CITY OF ALBUQUERQUE

November 27, 2022

Re: Little Star Day Care
1500 Coors Blvd. NW
90-Day Temporary Certificate of Occupancy
Transportation Development Final Inspection
Architect's Stamp dated 04-13-22 (J11-D045)
Certification dated 11-09-22

TCLIO

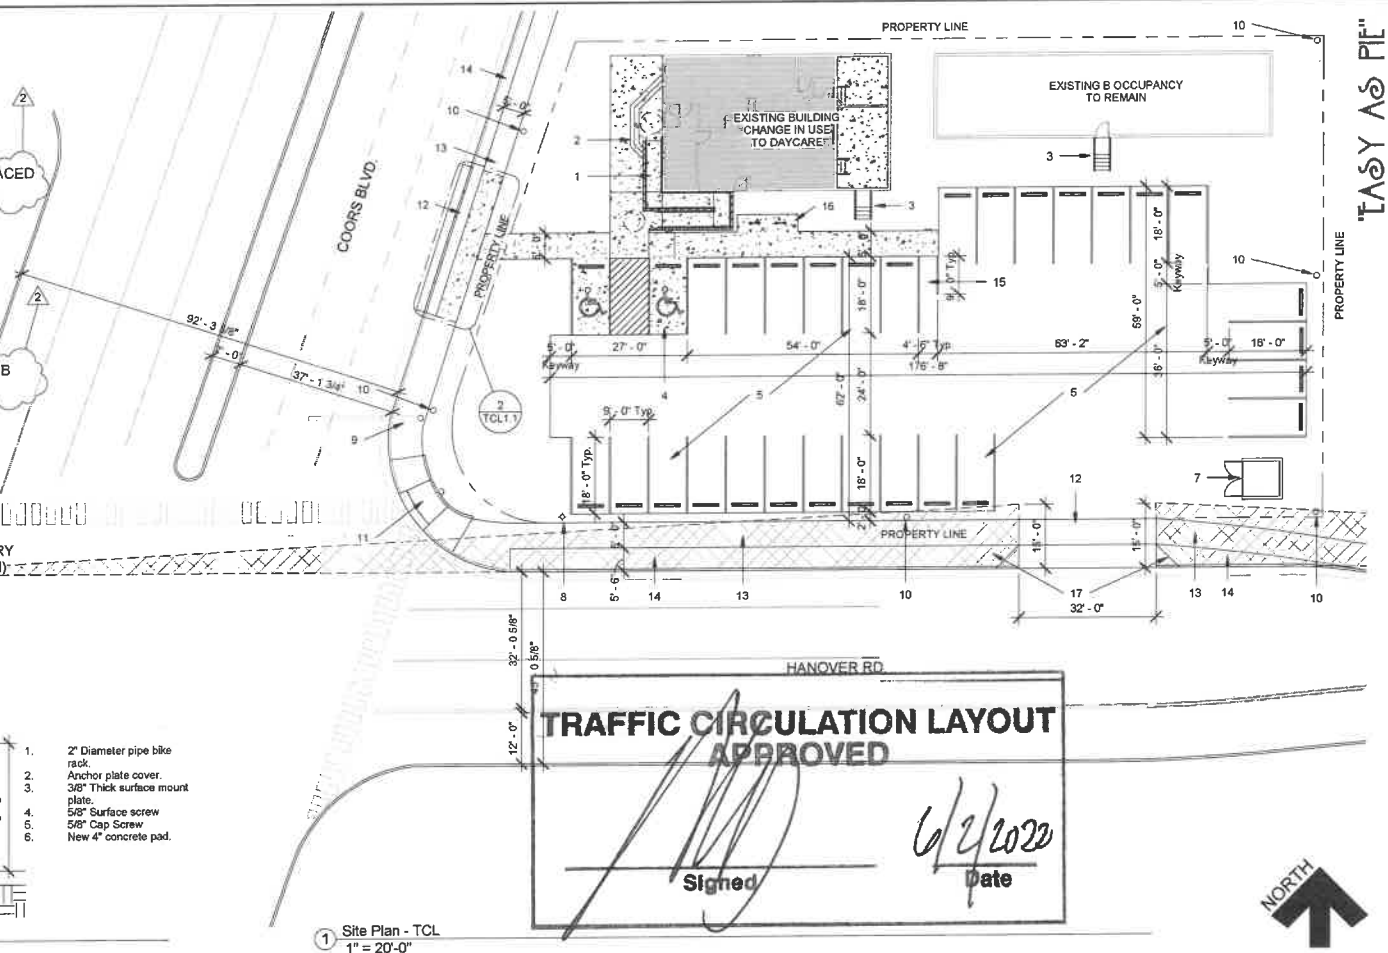
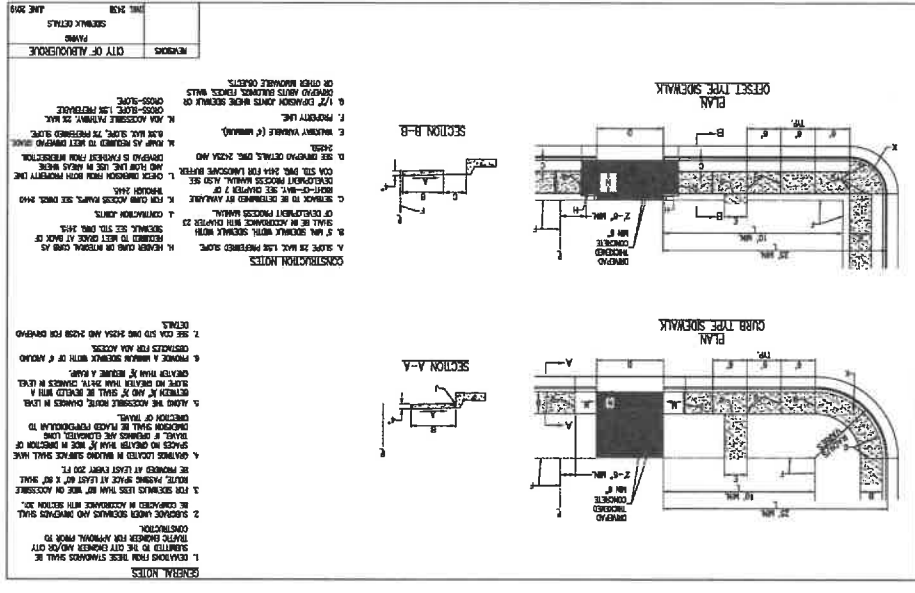
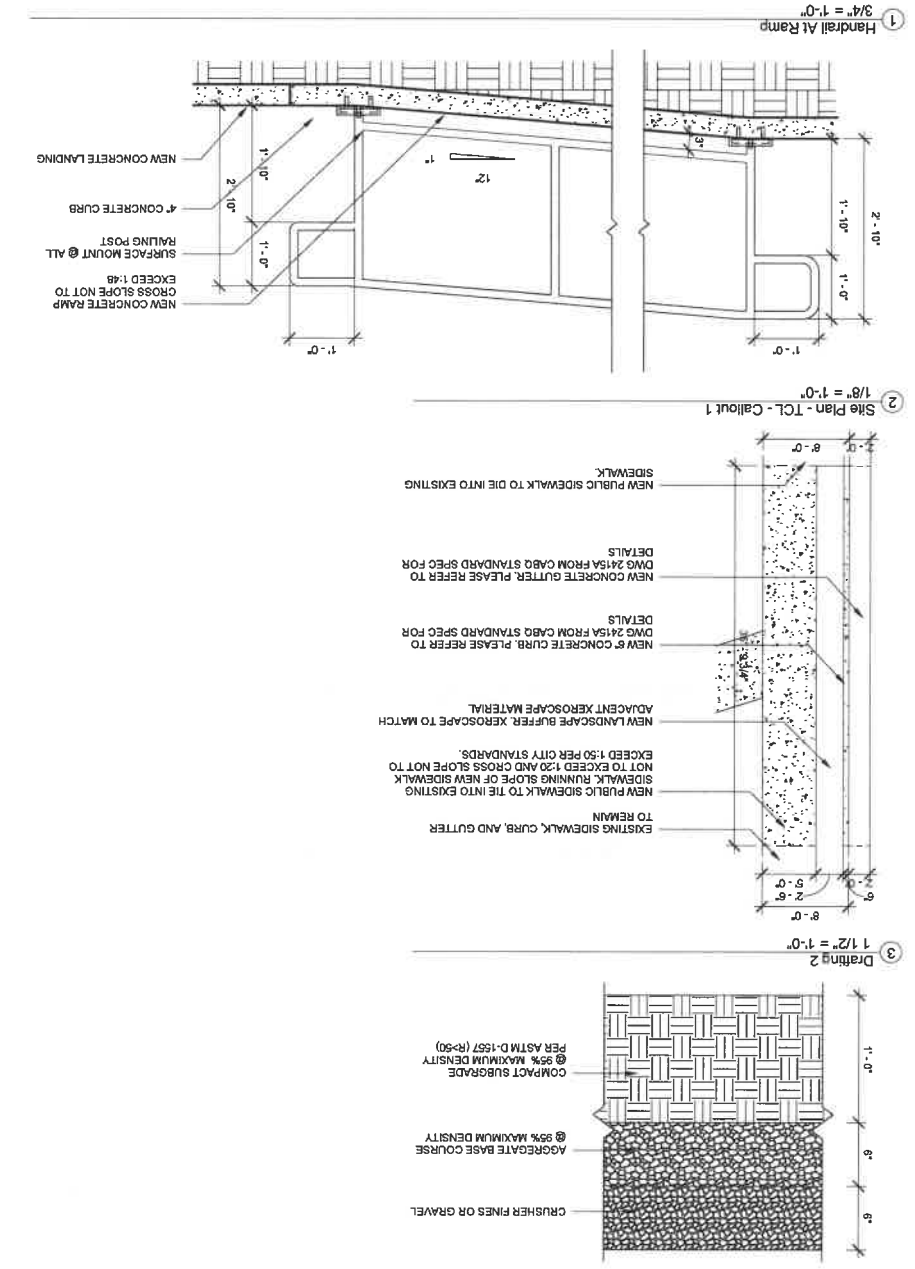
- Per approved TCL, Please close the unused curb cut off Coors Blvd. NW.
- The pavement marking "MC" should be shown in the opposite direction for Motorcycles entering the parking space.
